Preliminary Report on Metrolink Route and its Potential Effect on AerCap House

Waterman Moylan Consulting Engineers Limited

Client Name: Hines
Document Reference: 22-117r.101
Project Number: 22-117

Drawing Status: **FINAL**

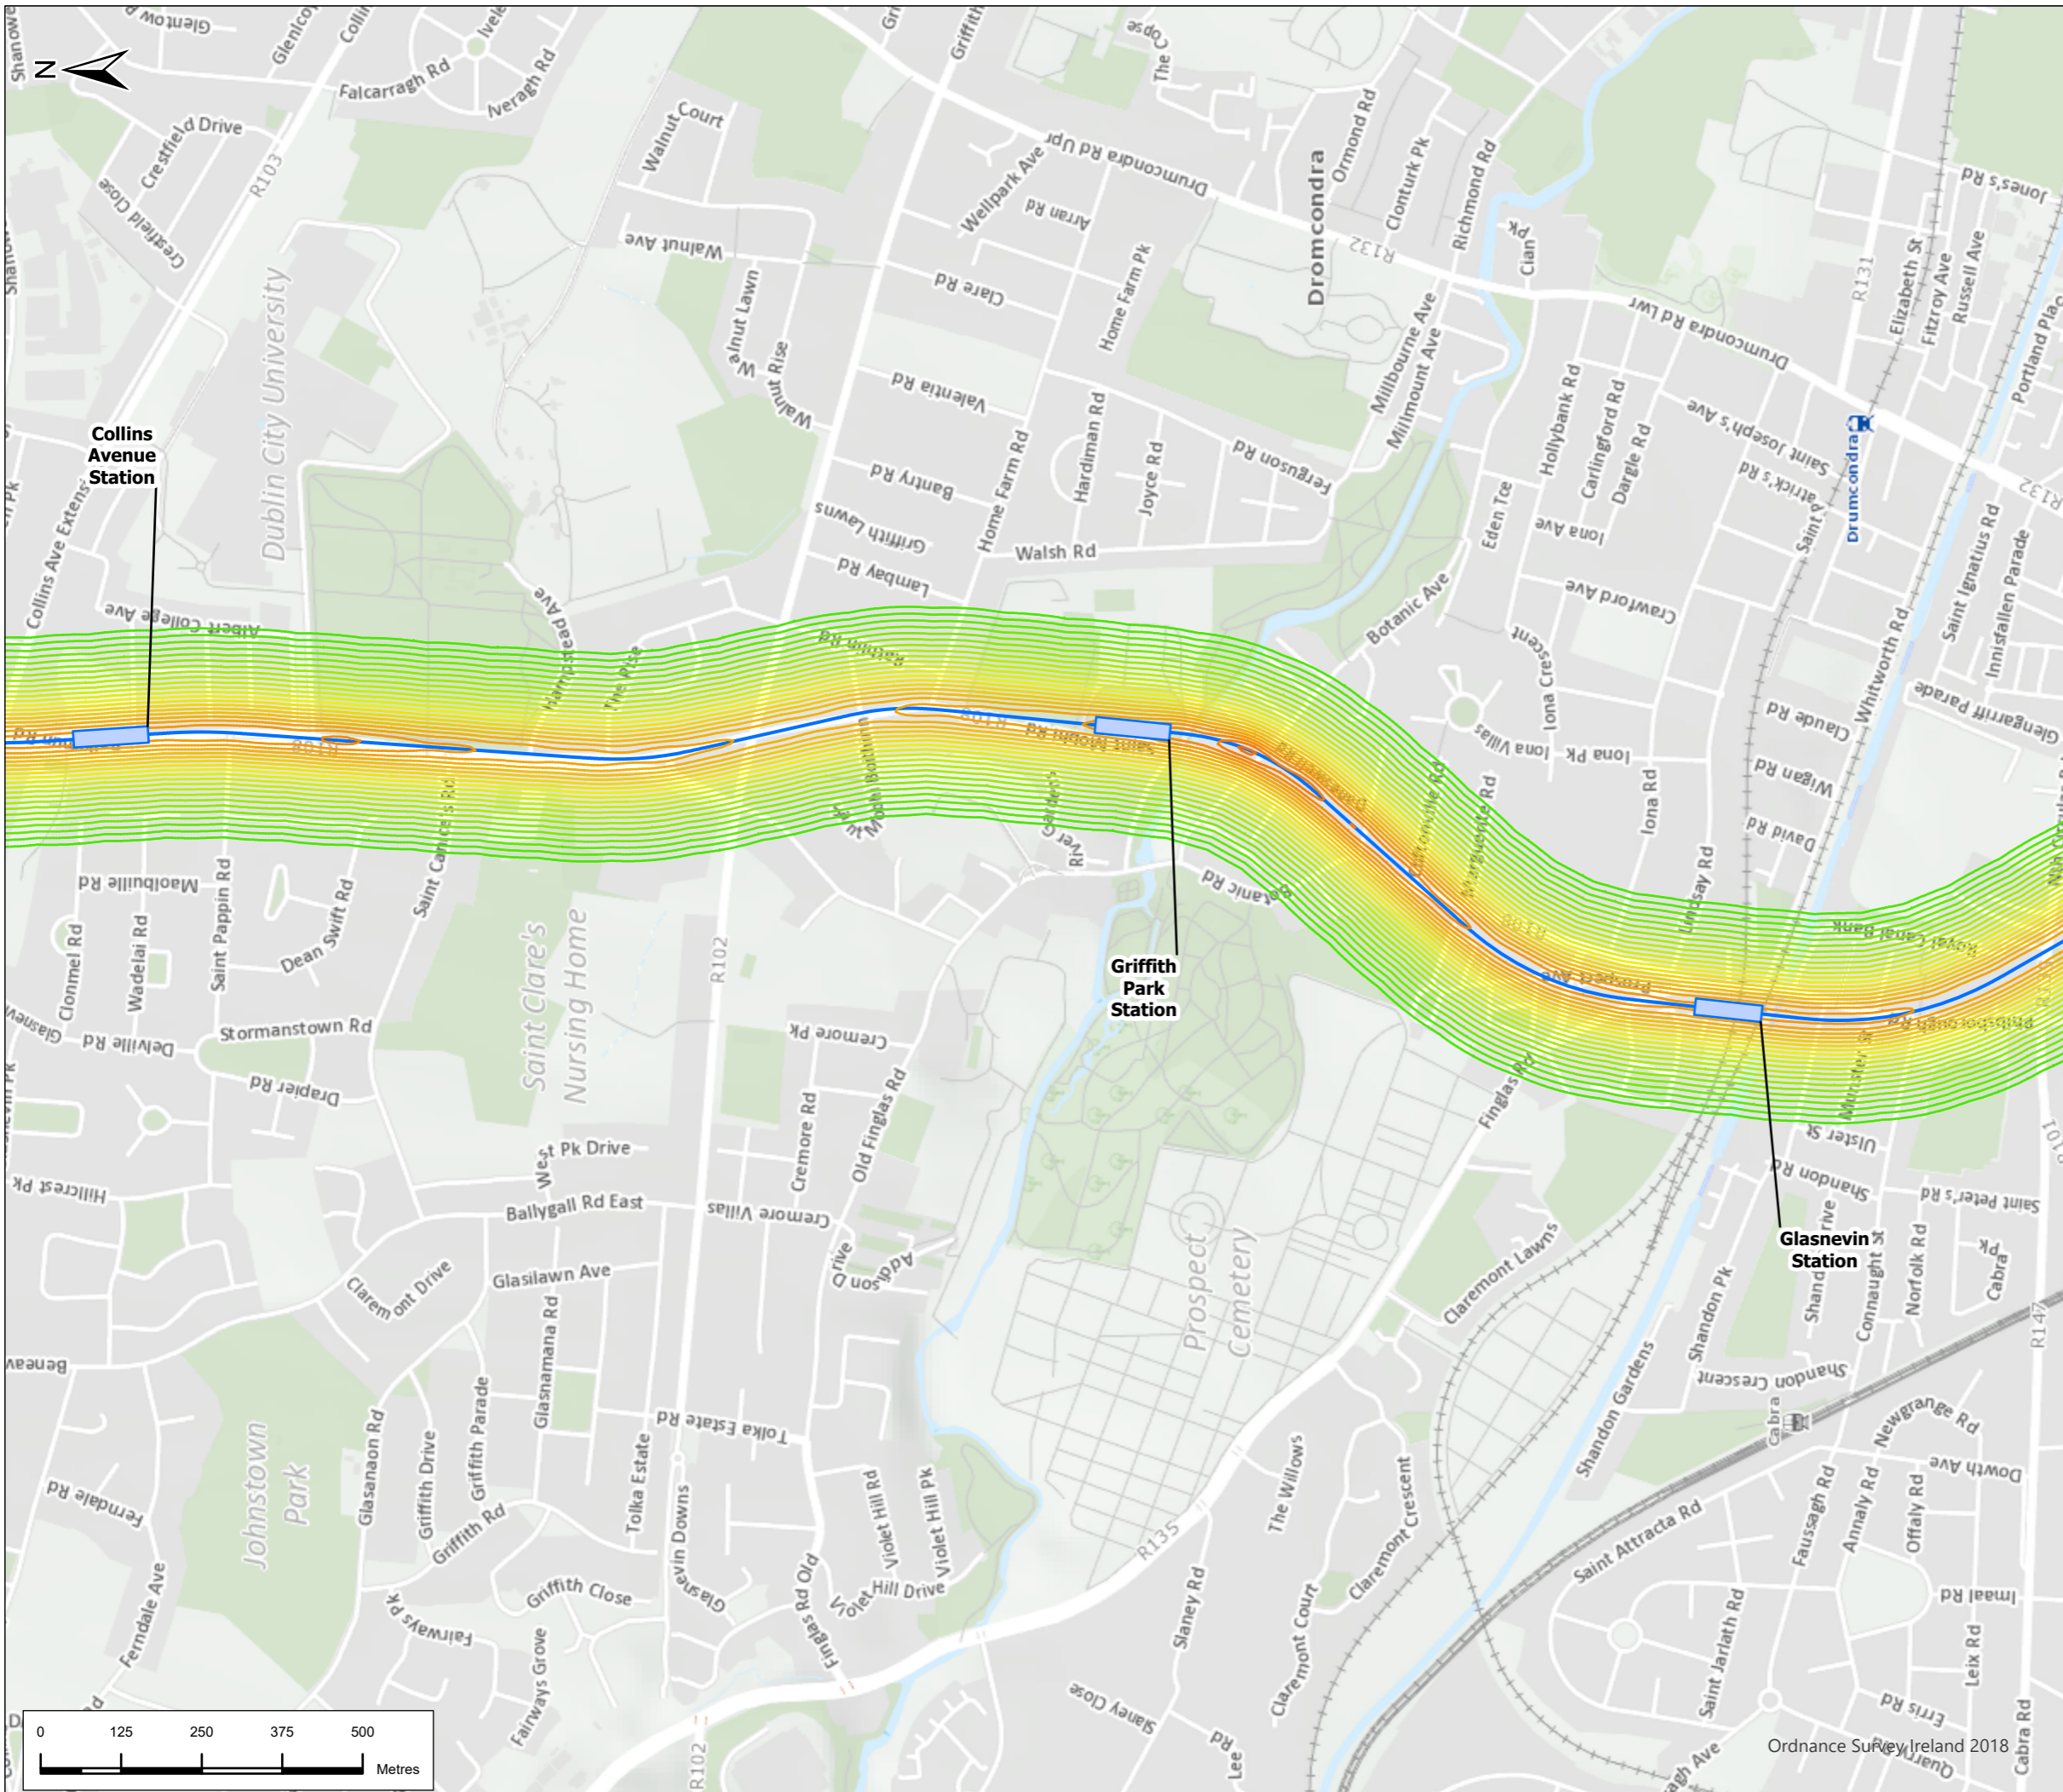
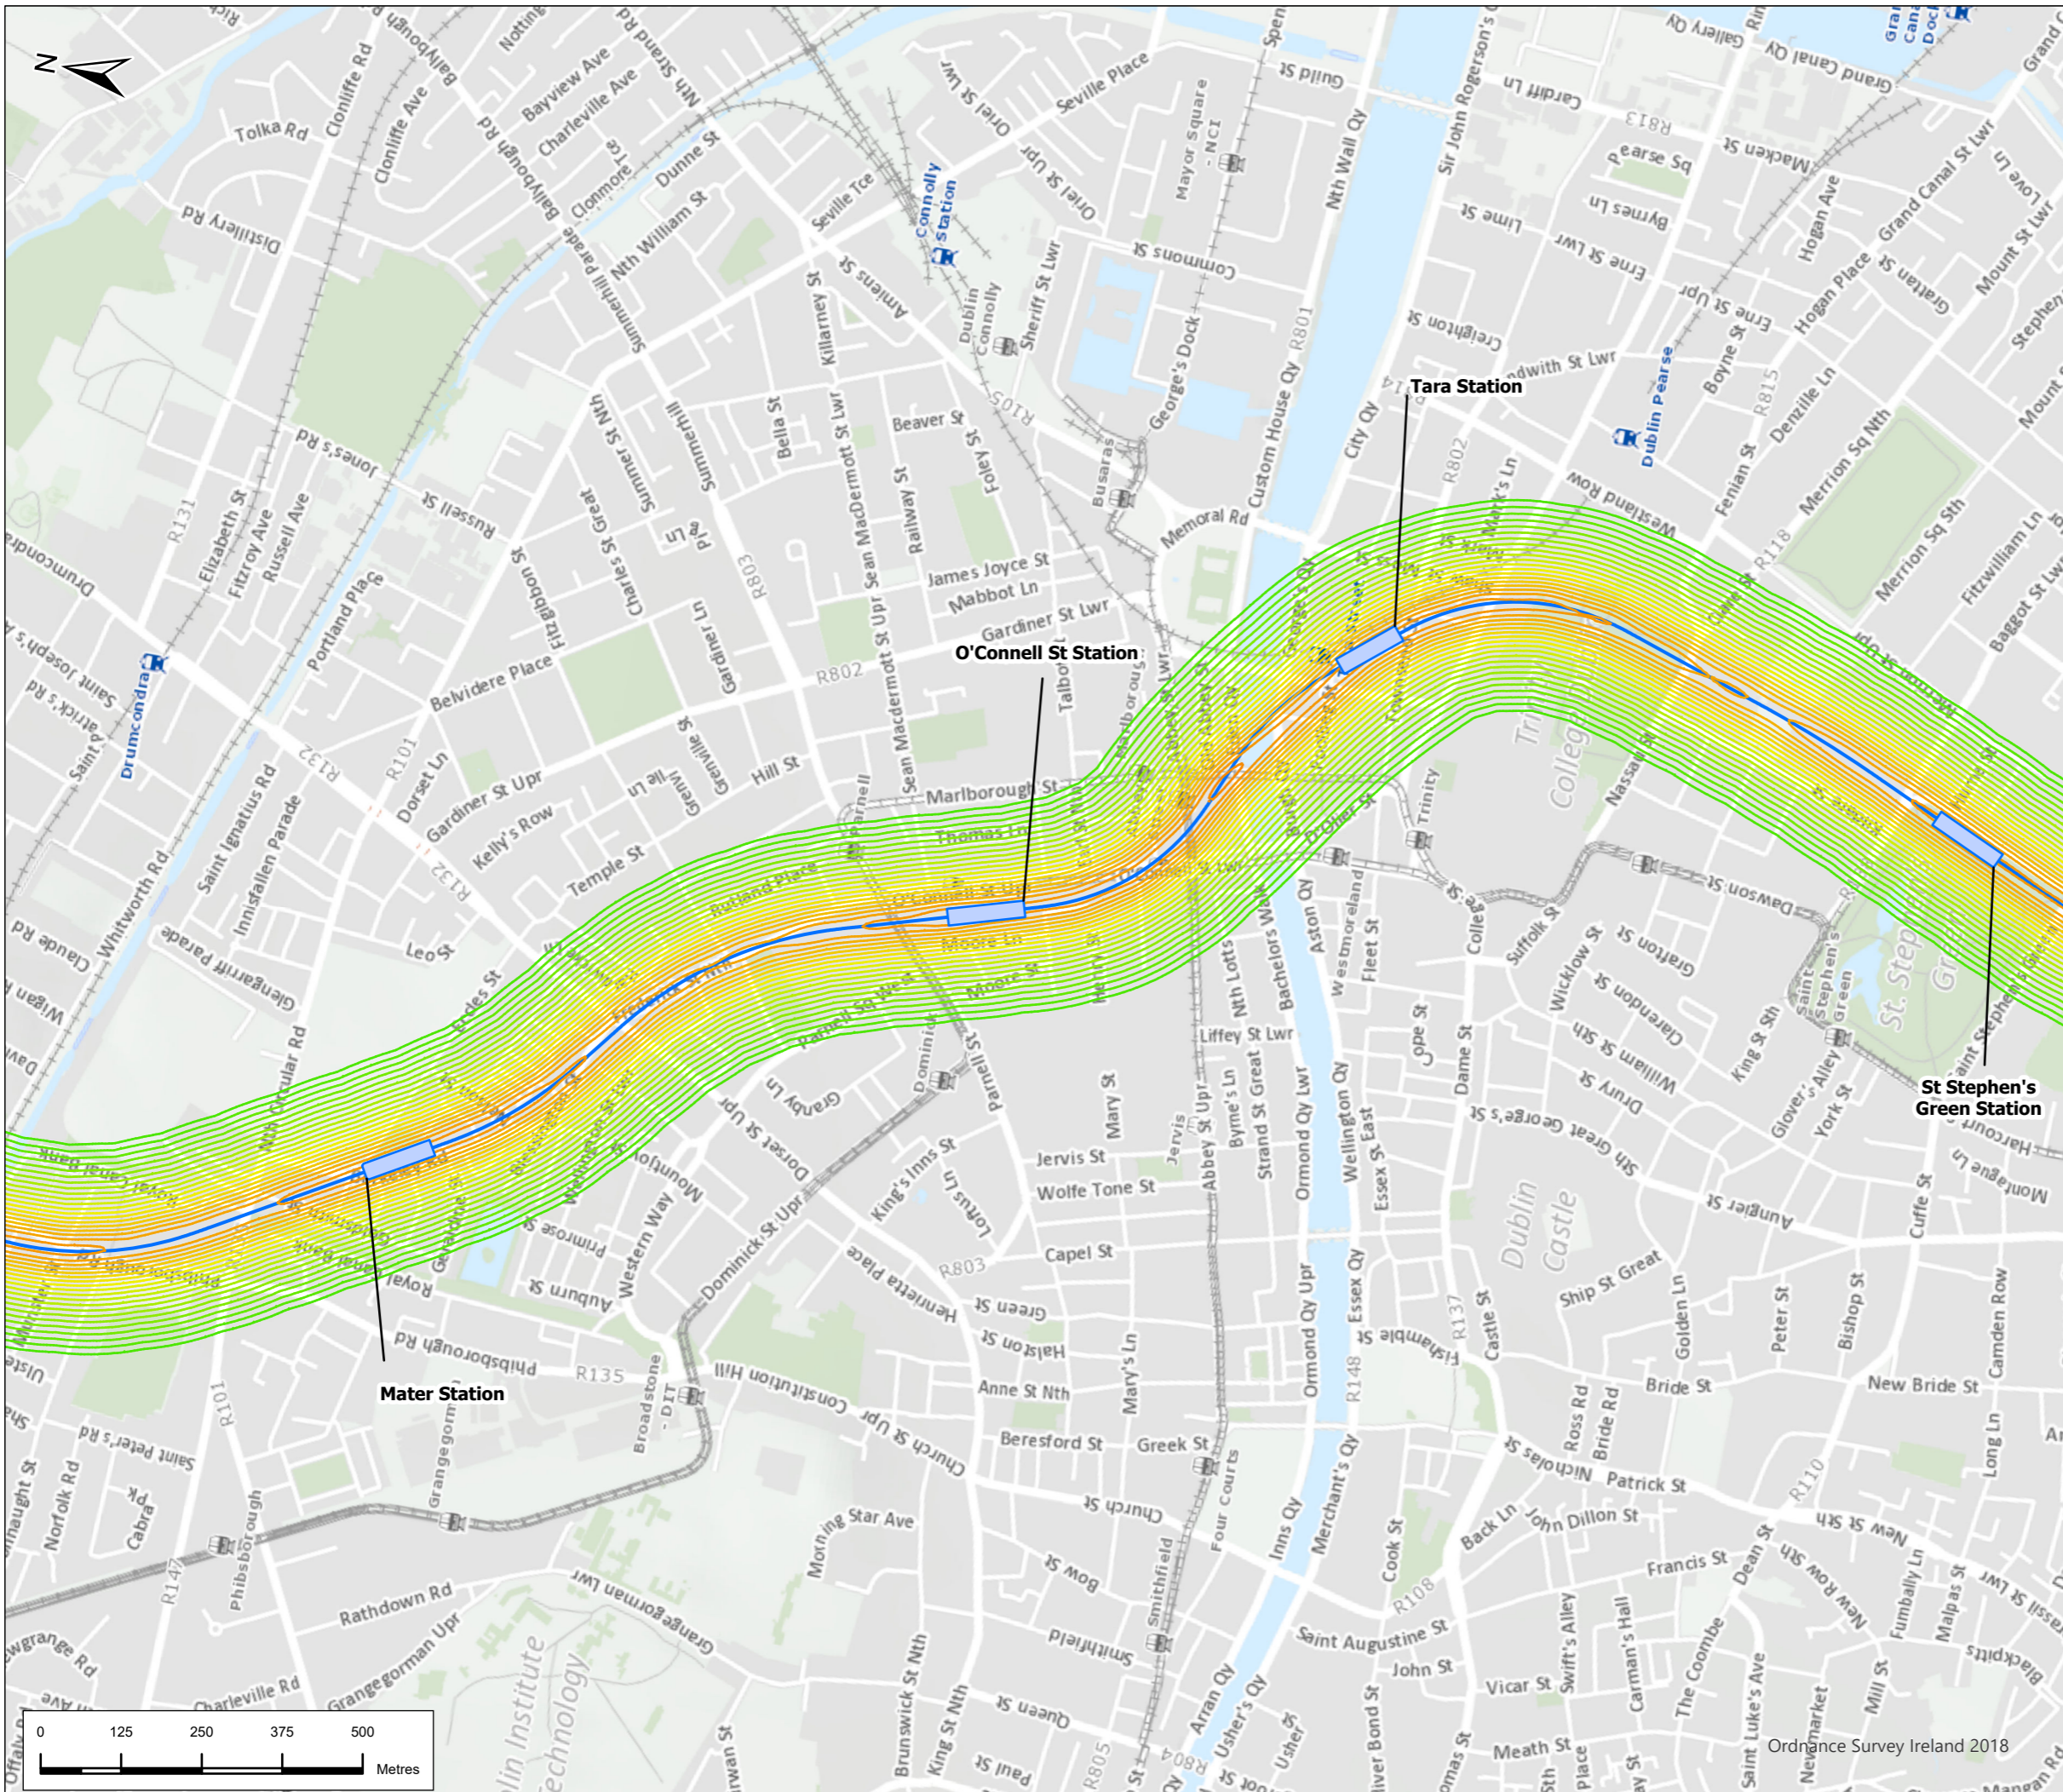
Observation (Waterman Moylan) 2: The construction information provided by MetroLink has been reviewed. We refer to the following points: a) Metrolink has assessed the "Groundborne Noise from Tunnel Boring Machine" and presents its findings on drawing no. ML1-JAI-EIAROUT-XX-DR-Y-14009 (a copy is attached to this submission). This drawing indicates MetroLink will generate an additional 50db directly under the location of our Client's building which is unacceptable.

Waterman Moylan Response 2: The response suggests that we need to accept the nuisance caused by the proposed works, and there is nothing that TII are willing to undertake to prevent this nuisance.

TII Response 2: *"Appendix 14.5 Groundborne Noise and Vibration Blasting Modelling Results presents predicted groundborne noise and vibration levels during the construction and operation phase of the project. The prediction of groundborne noise during TBM passage for the AerCap House (65 St. Stephen's Green) is 49 dB LASmax, which is above the 45 dB LASmax threshold, resulting a significant impact on the buildings operation for the limited duration of TBM passage. Unfortunately, there are no effective methods available to reduce groundborne noise or vibration from TBMs at source, but noting that the duration of this impact will be in the order of up to two weeks as the TBM passes. It is important to note that the noise level as the TBM passes will be noticeable and perhaps disturbing for some, but will not cause any damage to the property. TII will liaise with Hines Real Estate Ireland Limited to ensure the timing of these impacts are known. The principal mitigation measures aimed at minimising impacts are as follows:*

- *Advance public consultation and stakeholder engagement can greatly reduce the significance of groundborne noise effects, as building occupants would be prepared for the passage of the TBM and resultant elevated noise and vibration levels.*

- *TII will accept and consider applications for additional measures on a case-by case basis, in accordance with its Noise and Vibration Mitigation Policy (see EIAR Appendix A14.6, Airborne Noise & Groundborne Noise Mitigation Policy)."*
